**Applicant:** Orbit Homes (2022) Ltd

**Proposal:** Discharge of Conditions 6 (contamination), 10 (surface water drainage scheme), 11 (means of access (Phase I v Phase II), 15 (northern footpath link), 16 (Construction Environmental Management Plan) and 21 (External Lighting Strategy) of 21/03644/OUT

23/02713/DISC – Discharge of Conditions 6 (contamination), 10 (surface water drainage scheme), 11 (means of access (Phase I v Phase II), 15 (northern footpath link), 16 (Construction Environmental Management Plan), and 21 (External Lighting Strategy) of 21/03644/OUT.

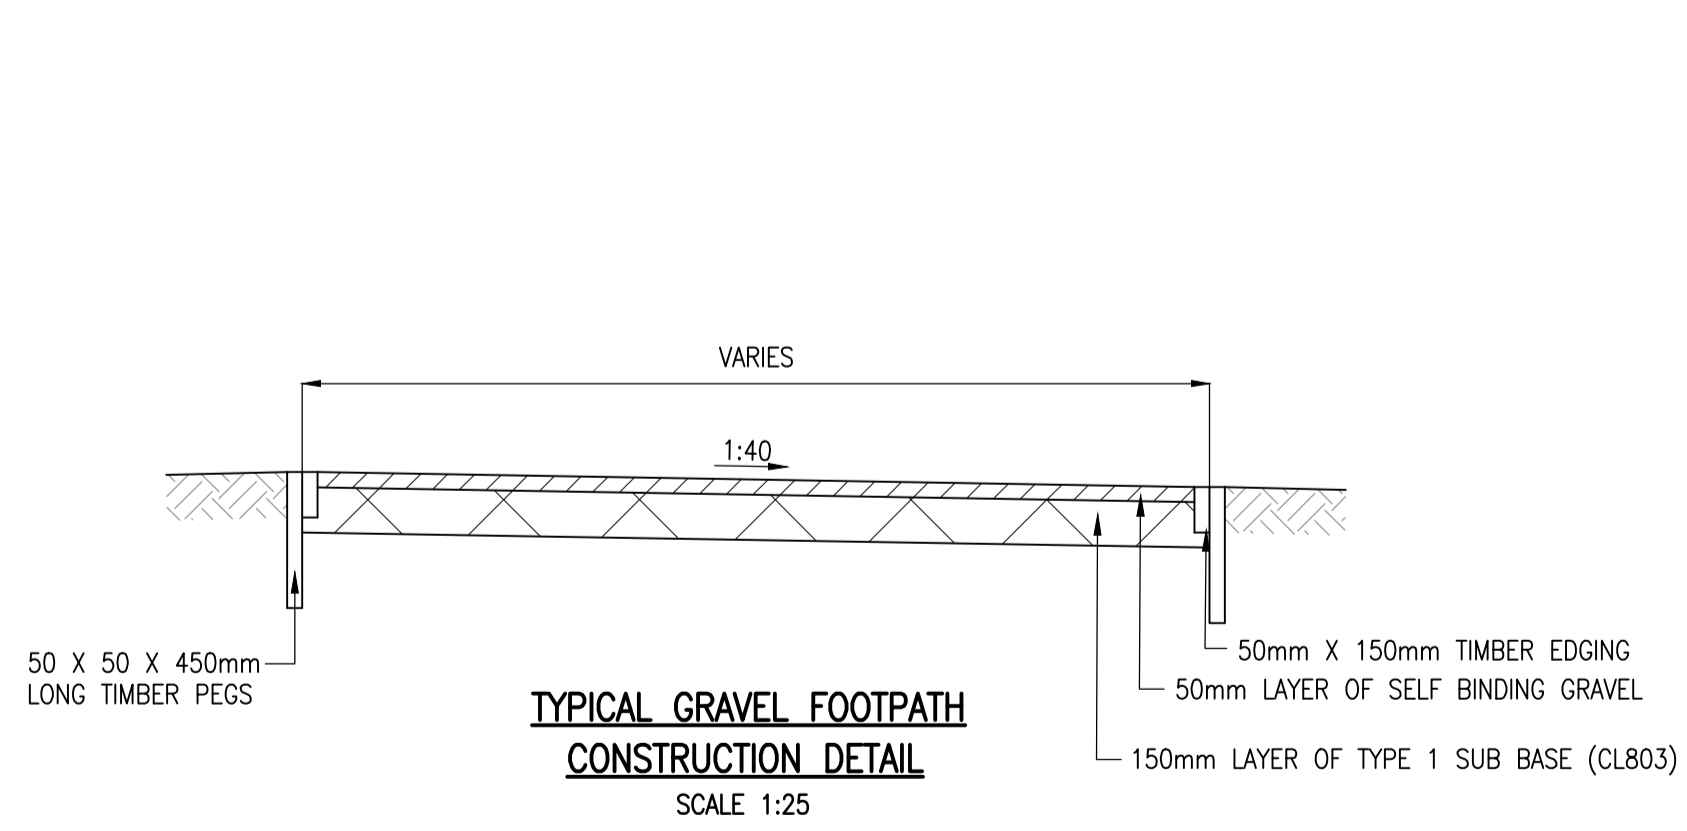
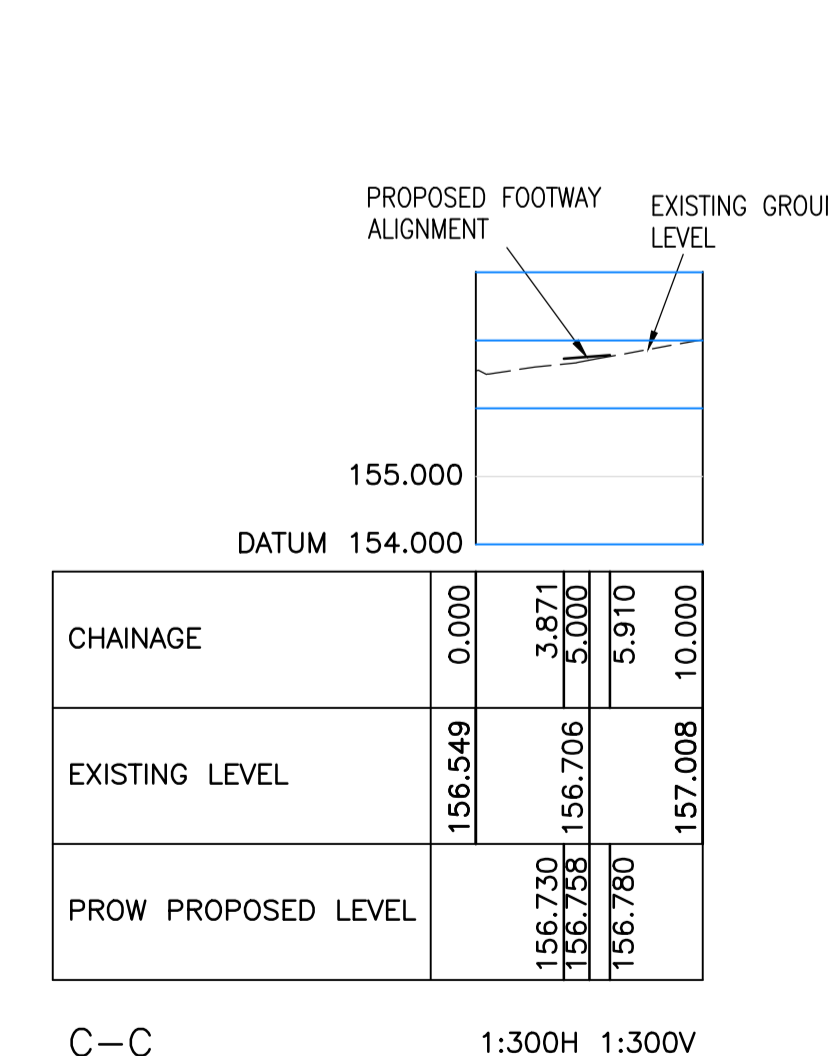
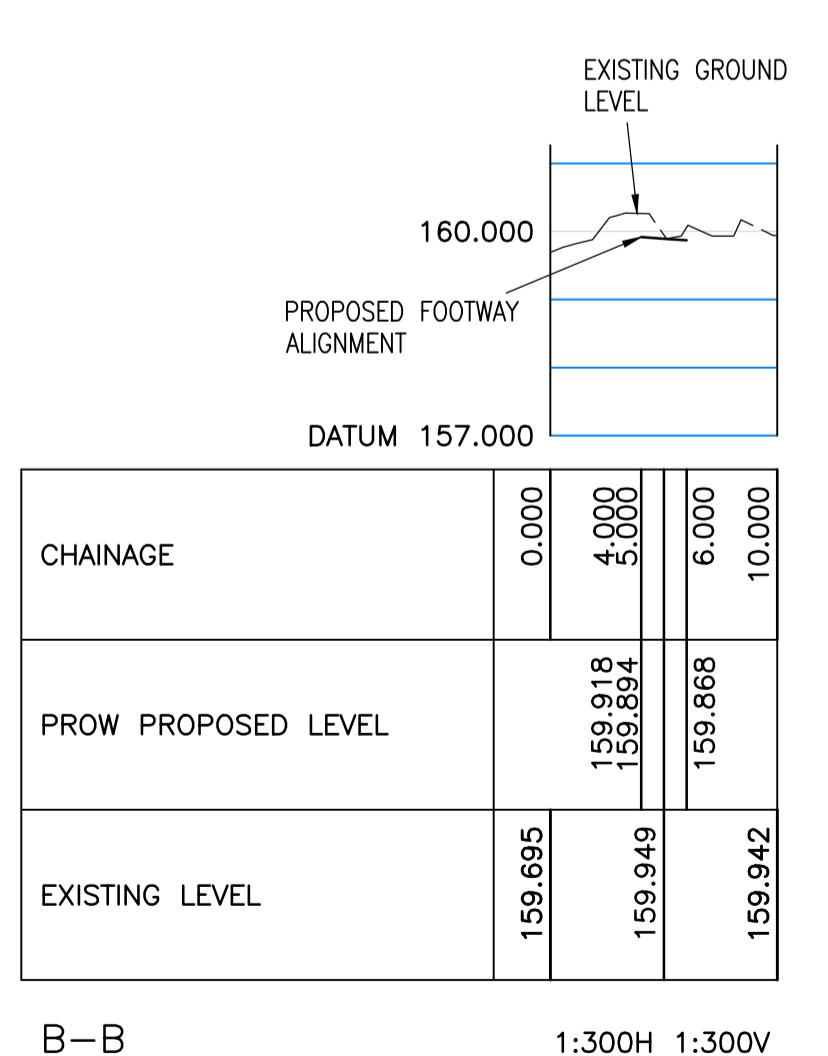
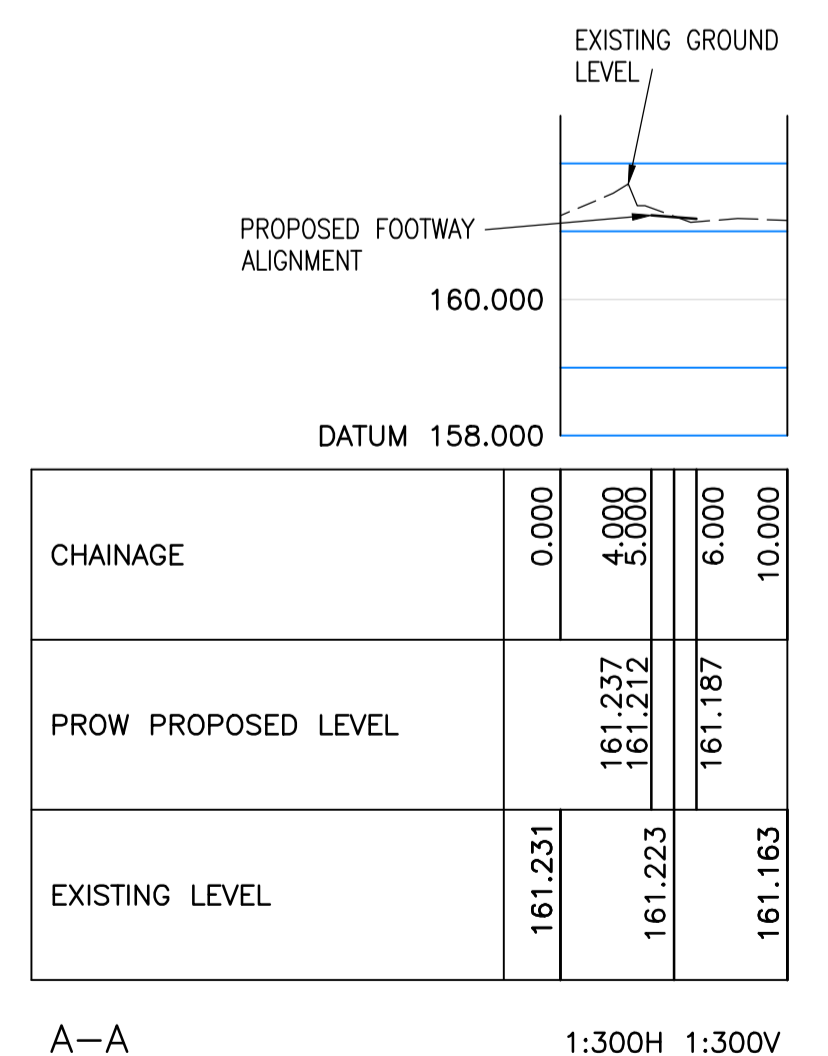
4.2 *CDC Landscape Services* – The PRow General Arrangement is concerning because of the excavations within the root protection area of existing retained trees and hedgerow putting them at risk, reducing their amenity, and their screening potential for visual receptors. All works must be reconsidered in accordance with BS5837: 2012 Trees in relation to design, demolition and construction – Recommendations. A qualified arboriculturist must assess the proposals and provide the most appropriate solution to this matter, whether a raised surface solution or mown or mulched path.

- The submitted PRow General Arrangement plan shows a bound gravel footway construction proposed adjacent to the North boundary. The plan also shows cross sections and levels plans that appear to show excavation of the existing levels to construct the proposed path.

- As shown within the Arboricultural Report submitted with application 21/03644/OUT, a large number of trees are located within this area. Where the works are proposed are within the RPAs of a large number of trees and excavation to construct the path will have significant adverse impacts to these trees and is not acceptable from an arboricultural perspective.

- From the information submitted it has not been possible to determine if the existing Public Right of Way is surfaced. Could the path remain as existing, retaining the existing levels? If a surfaced path is required, then an Arboricultural Impact Assessment in accordance with BS 5837:2012 will be required to be completed by an arboriculturist to accurately assess the proposed works and provide details of suitable mitigation. The design will also be required to comply with section 7.4 of BS 5837:2012 and also

Arboricultural Association's Guidance Note 12, implementing a No Dig Cellular Confinement System methodology.

- 5.15. OCC as County Highway Authority has assessed the submission and has raised no objections.
- 5.16. CDC Arboricultural Officer has also assessed the details and has stated that the submitted PROW General Arrangement plan shows a bound gravel footway construction proposed adjacent to the North boundary. The plan also shows cross sections and levels plans that appear to show excavation of the existing levels to

construct the proposed path. However, this is consistent with the details shown for the path within Phase I (the adjacent site to which it connects).

- 5.17. The Officer also states that the Arboricultural Report submitted with application 21/03644/OUT, outlines that a large number of trees are located within this area and that works are proposed are within the RPAs of a large number of trees and excavation to construct the path will have significant adverse impacts to these trees and is not acceptable from an arboricultural perspective. However, such matters were addressed in the outline consent and that all works that might impact on trees will be undertaken in accordance with BS 5837:2012 along with the approved Arboricultural Report and Tree Survey.

- 5.18. The Officer has also queried whether the existing Public Right of Way is surfaced and whether the path remain as existing, retaining the existing levels. However, the path is not currently surfaced and has been designed to enhance it as per the request of the authority at outline stage planning stage and is also consistent with the path falling within the adjacent Phase I land.
